Memorandum

To: Mathew Wiley
CC: The Miller Hull Partnership LLP c/o April Ng
Site: Wiley Residence Remodel
Address: 6838 96th Ave SE, Mercer Island
Re: Assessment of Impacts to Tree 344 from Soldier Pile Wall Installation in Driveway
Date: January 10, 2024
Project Arborist: Connor McDermott,
ISA Certified Arborist PN- 8704A
ISA Qualified Tree Risk Assessor
Referenced Documents: Arborist Report (Tree Solutions Inc, 05/12/2022)
Grading Plan C200A (LPD Engineering, February 24, 2023)
Foundation Details (PCS Structural Solutions, February 24, 2023)
Garage Shoring and Wall Elevation Details S420 (PCS Structural Solutions, December 8, 2023)

I was asked by the project team to assess revisions to the construction of a retaining wall within the recommended limits of disturbance (RLOD) of tree 344. I was to produce a memo of my findings following a corrections response of the revised plan set from the City of Mercer Island.

GRADING PLAN

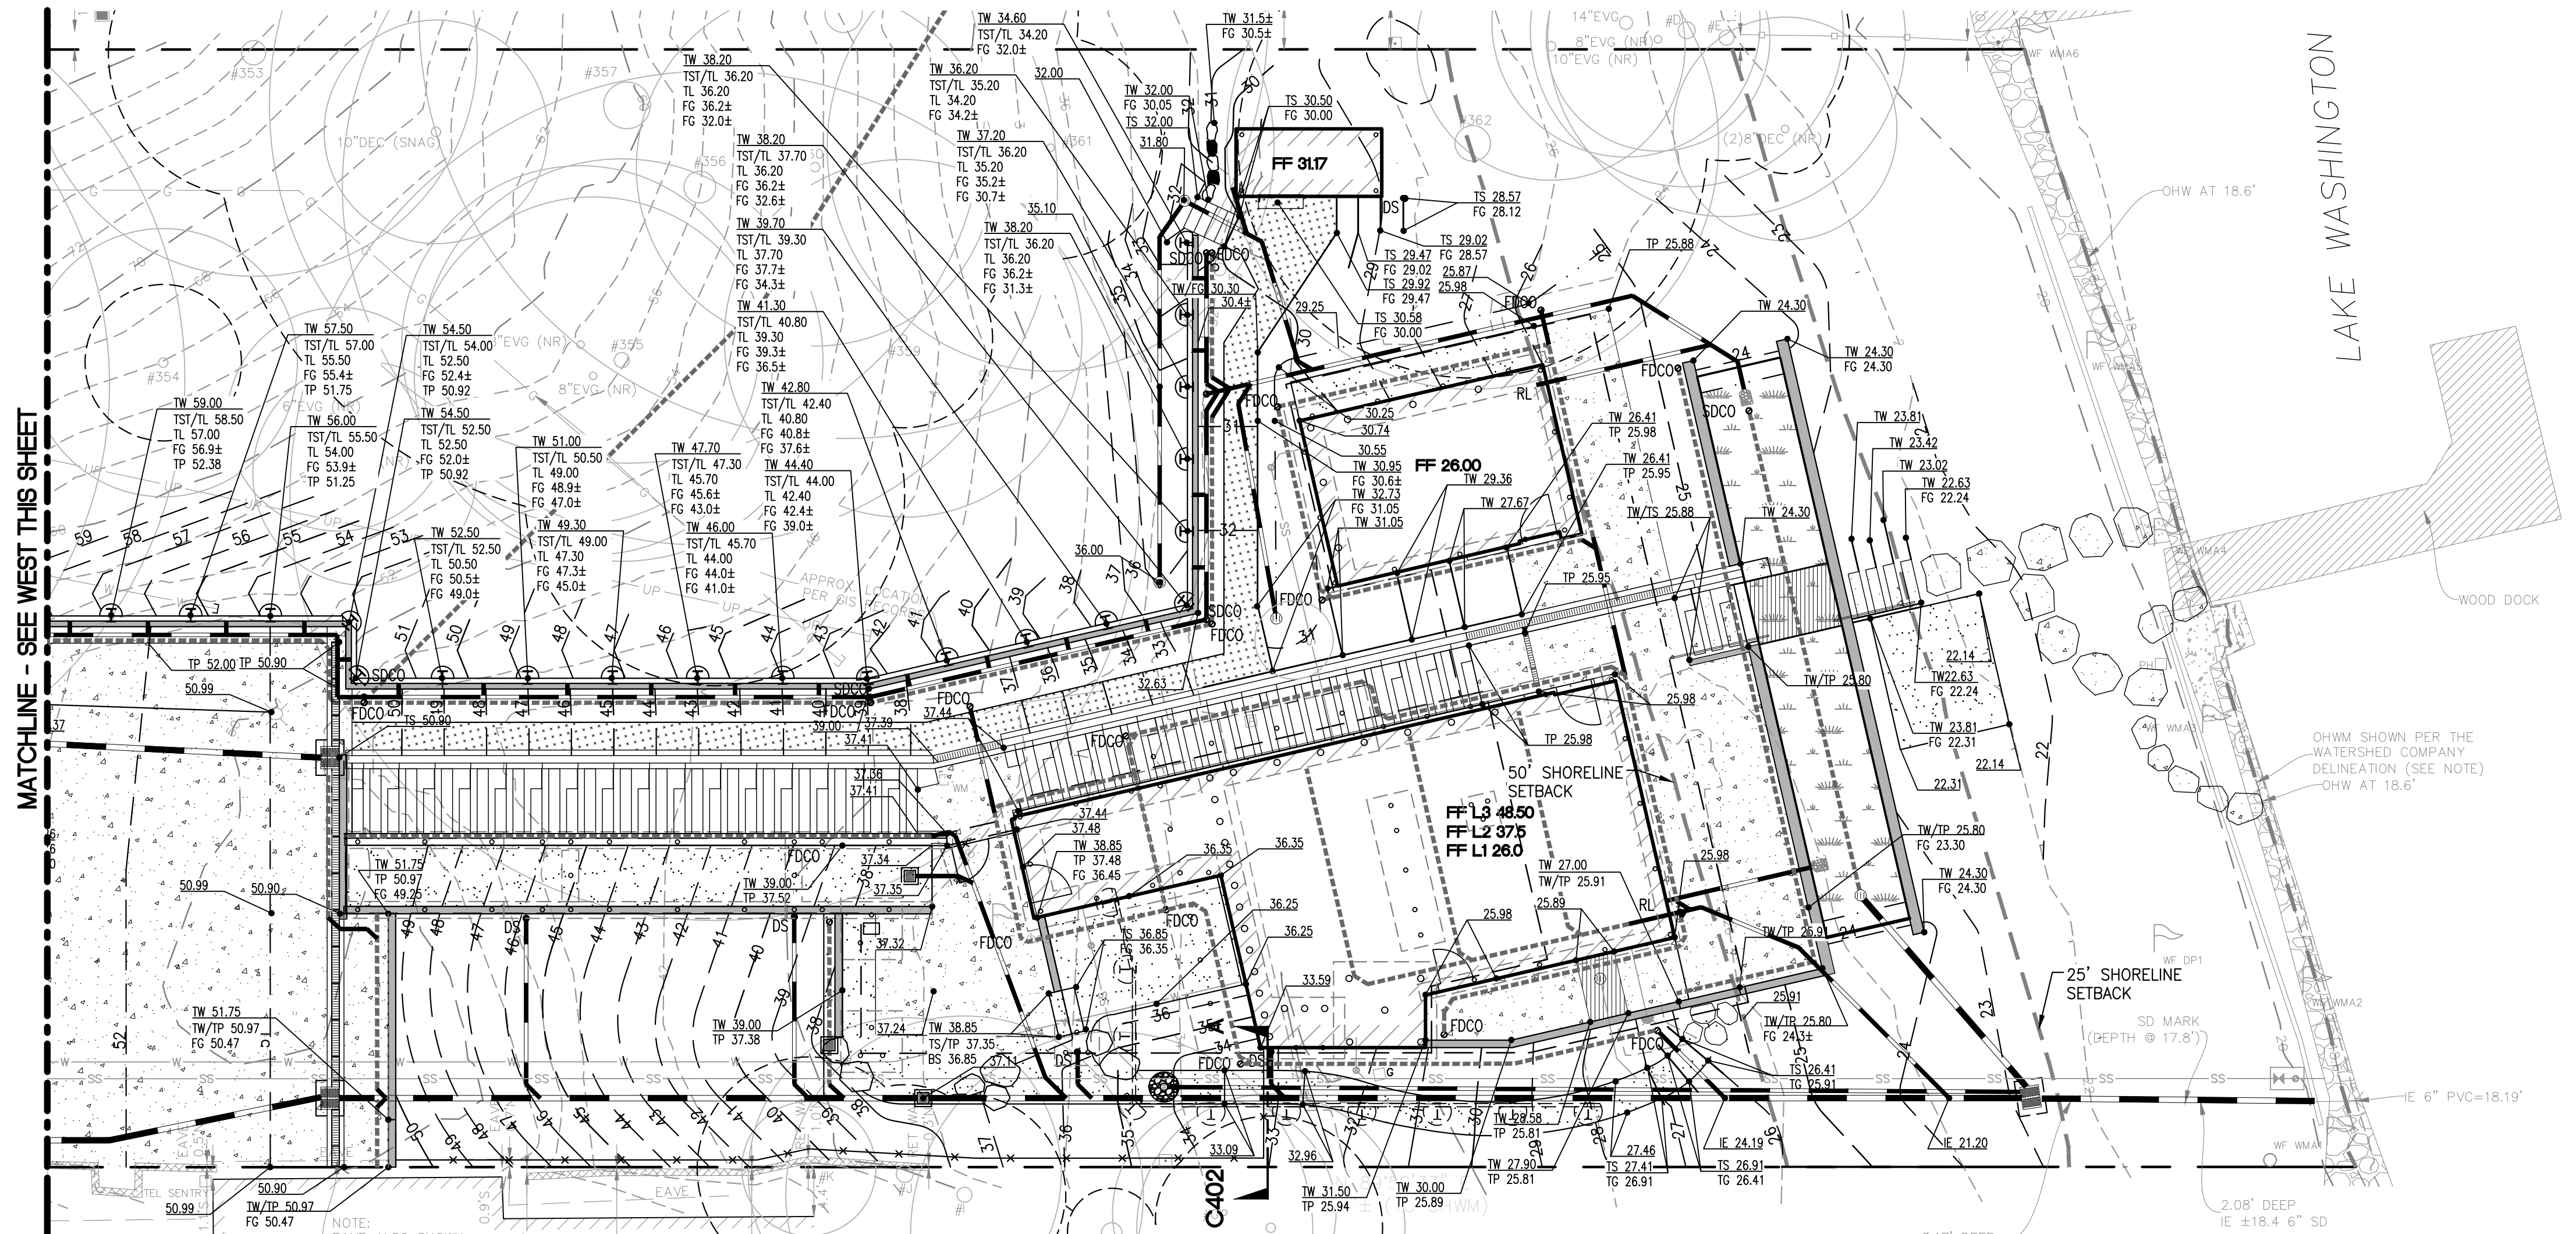
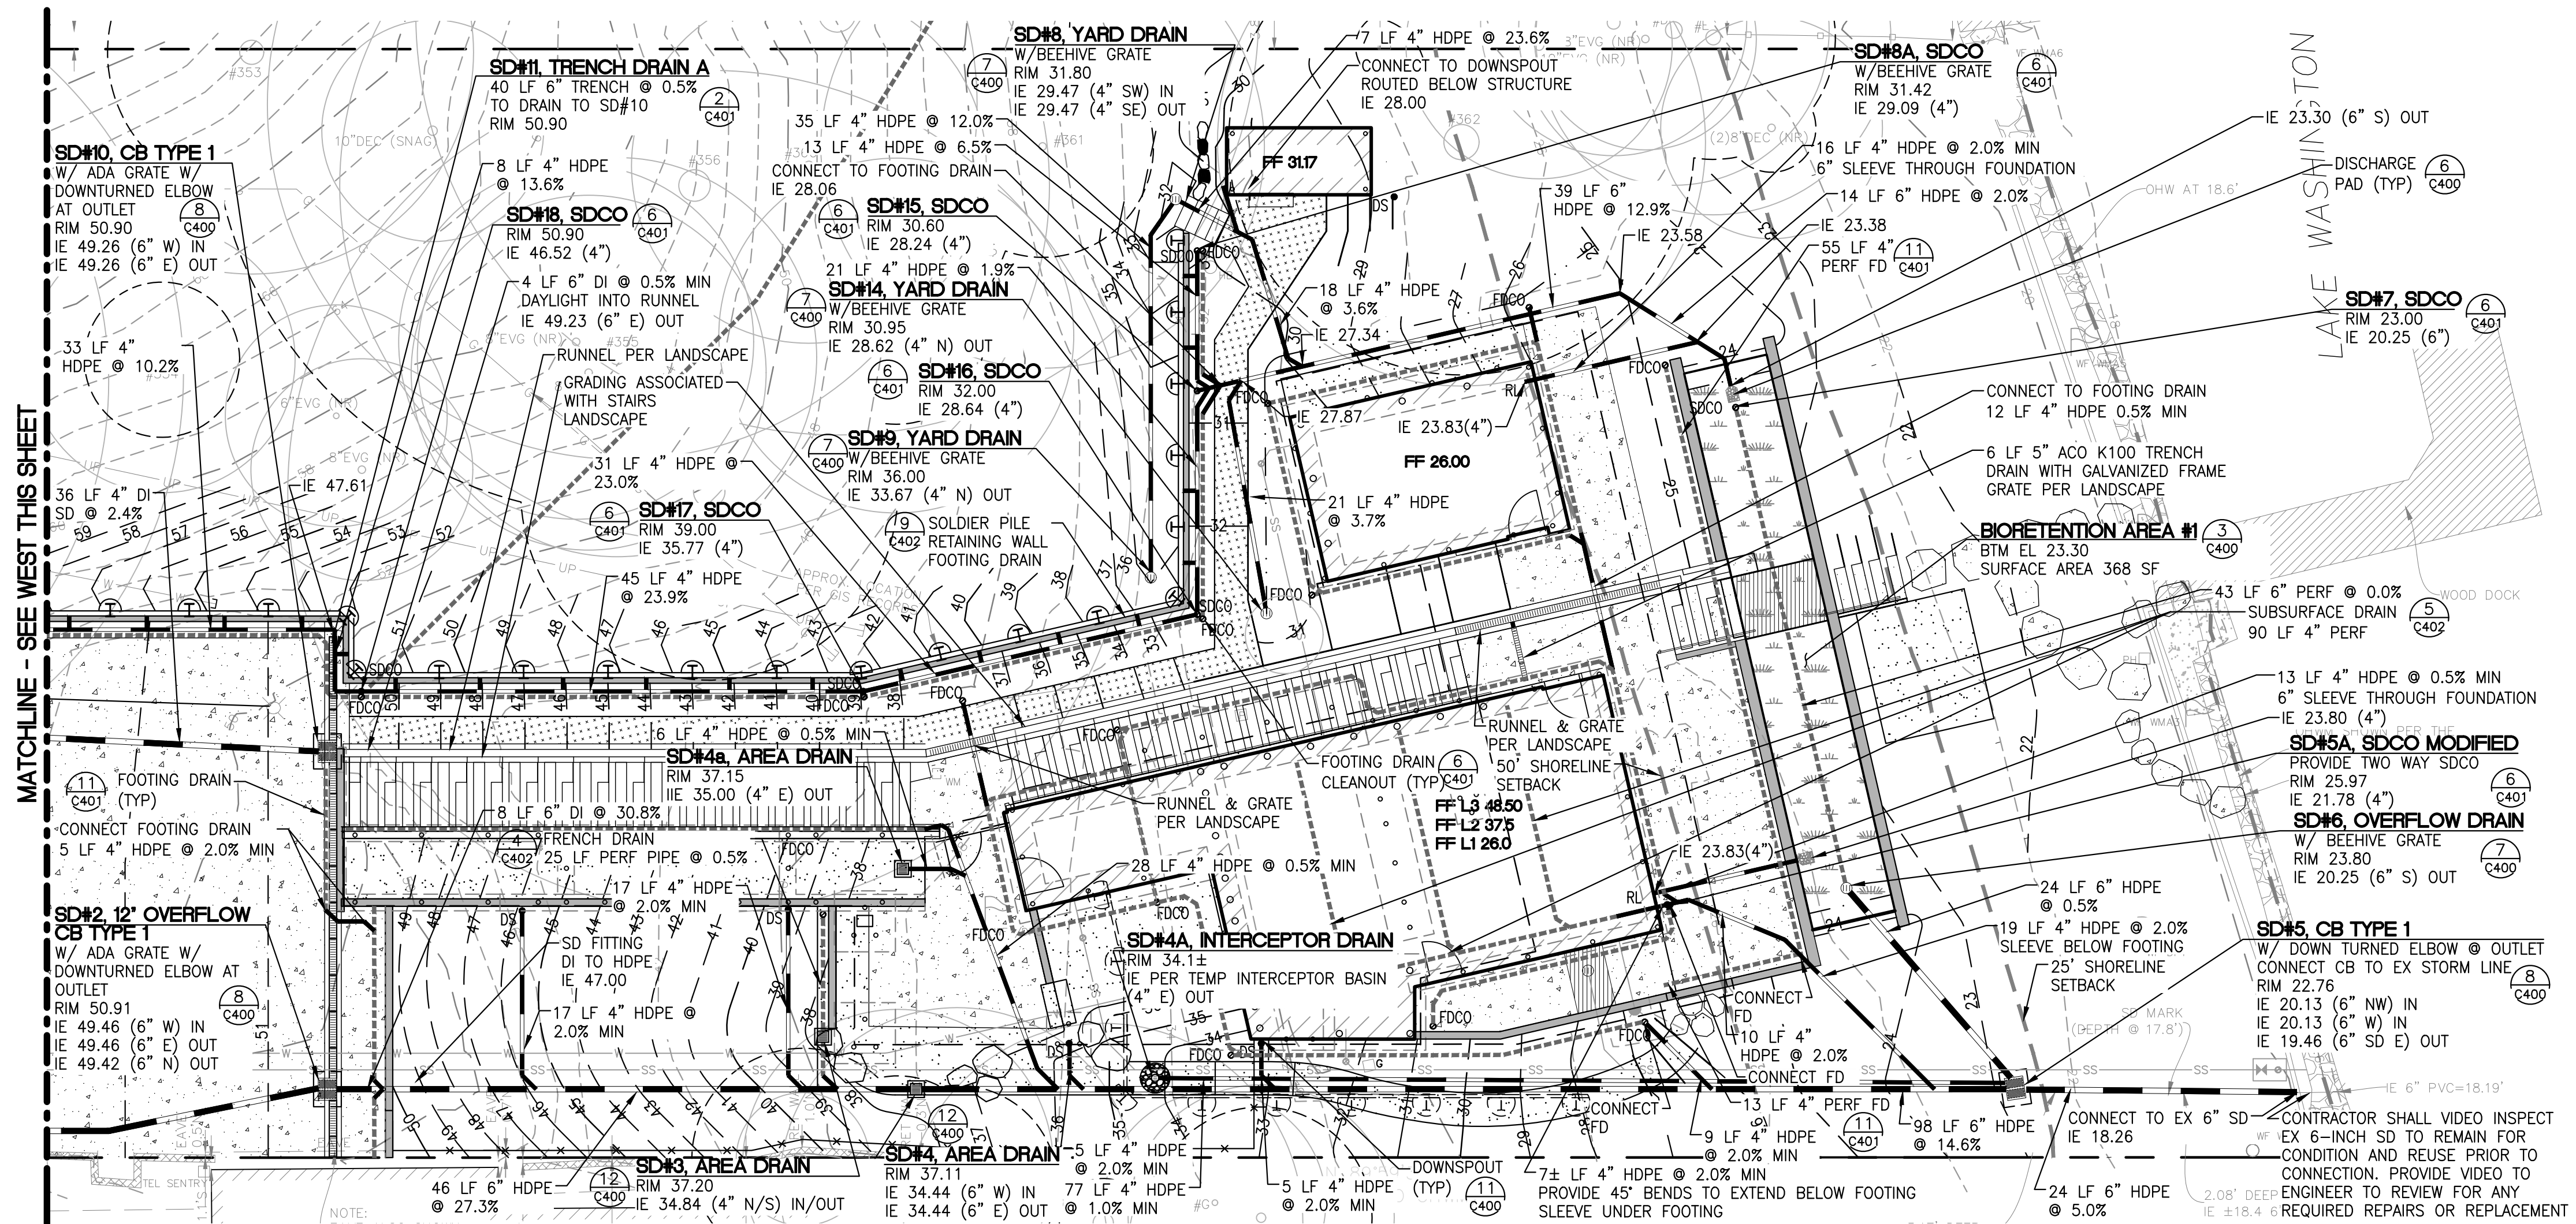
Tree 344 is an exceptional western redcedar that measured 49.7-inch diameter at standard height and had a RLOD of 33 feet. The approved construction plans called for the construction of a concrete retaining wall south of the existing driveway and north of tree 344 (Figure 1). The foundation of the concrete retaining wall had a four foot wide footing that required encroachment into the minimum limits of disturbance (MLOD) of tree 344 and up to 15 feet from the base of the tree (Figure 2).

SOLDIER PILE WALL PLAN S400

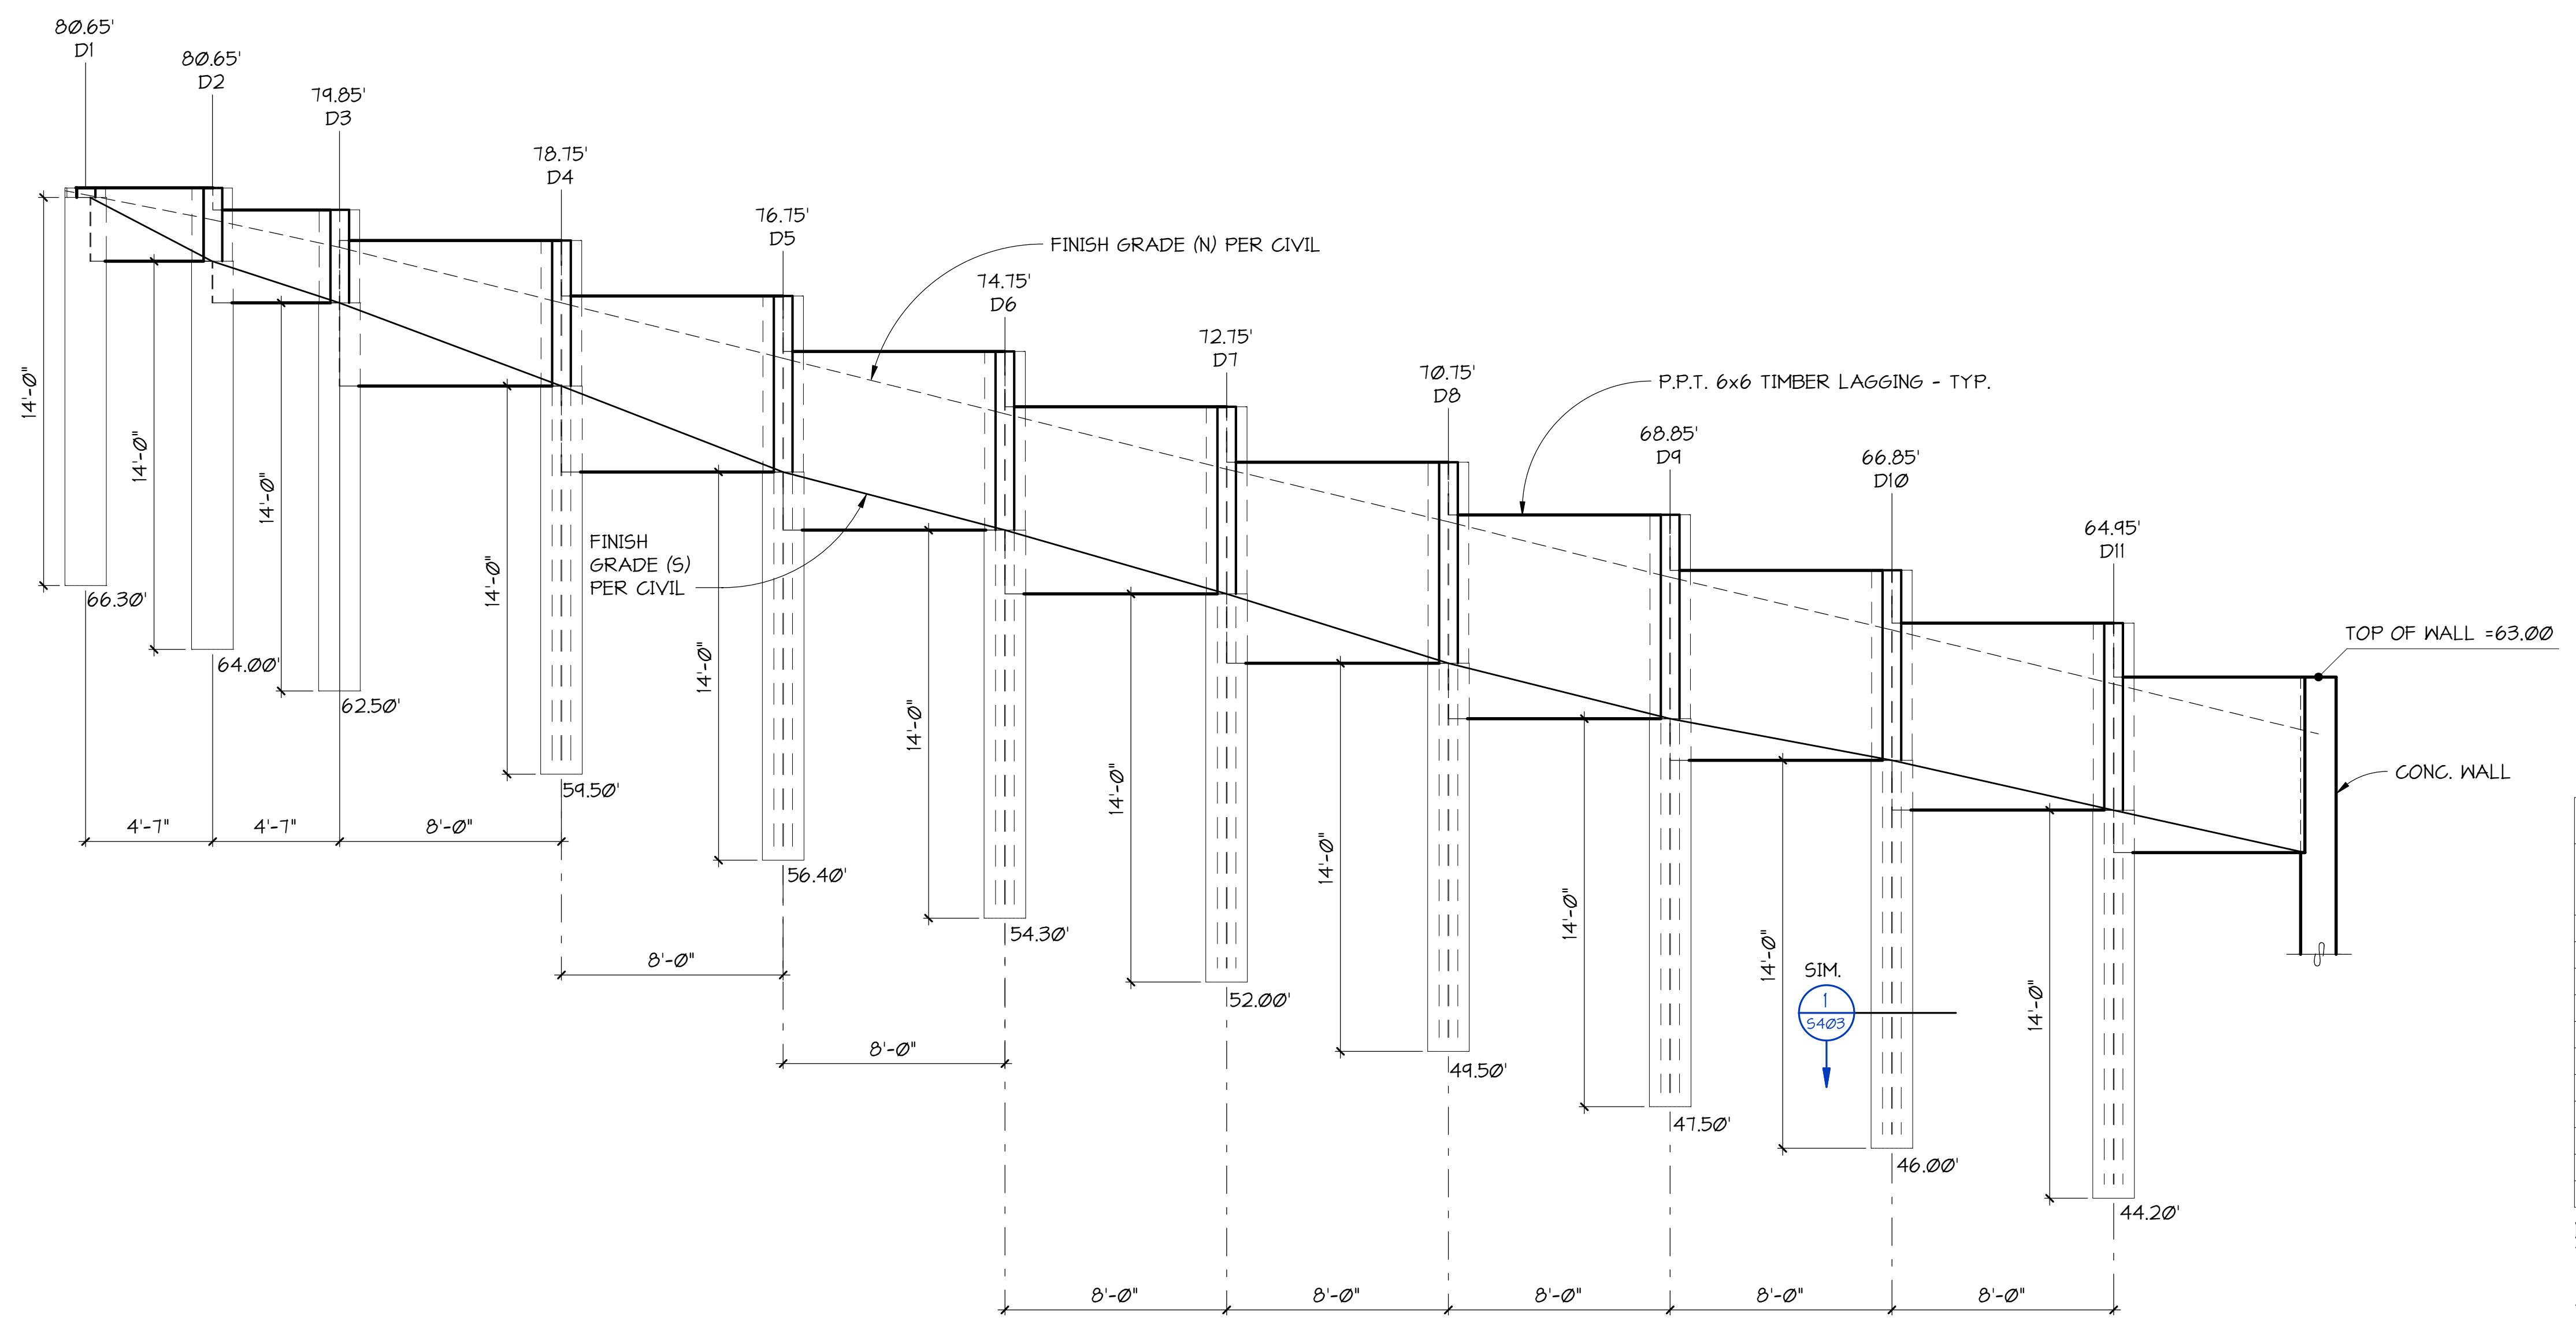
Due to these impacts, the project team developed an alternative solution to install the retaining wall by utilizing soldier piles. Based on my discussion with the project team, this approach would reduce the encroachment into the RLOD of tree 344 by three or more feet and could be installed from the existing driveway utilizing an auger.

Based on my assessment of the plans available, the impacts to tree 344 are limited from the construction of the soldier pile wall and installation of the wall will not require encroachment into the MLOD of the tree.

I believe the long term health of tree 344 will not be impacted if excavation within undisturbed soils is limited to the placement of beams for the piles. I recommend the location of the piles are first ground

with a grinding or reciprocating attachment head on the auger for the initial four feet to cleanly cut any roots in the vicinity. No machinery or materials should be stored on top of undisturbed soils within the RLOD of the tree. I recommend the installation of the piles within the RLOD of tree 344 are monitored by the project arborist to guide installation and determine rooting impacts.
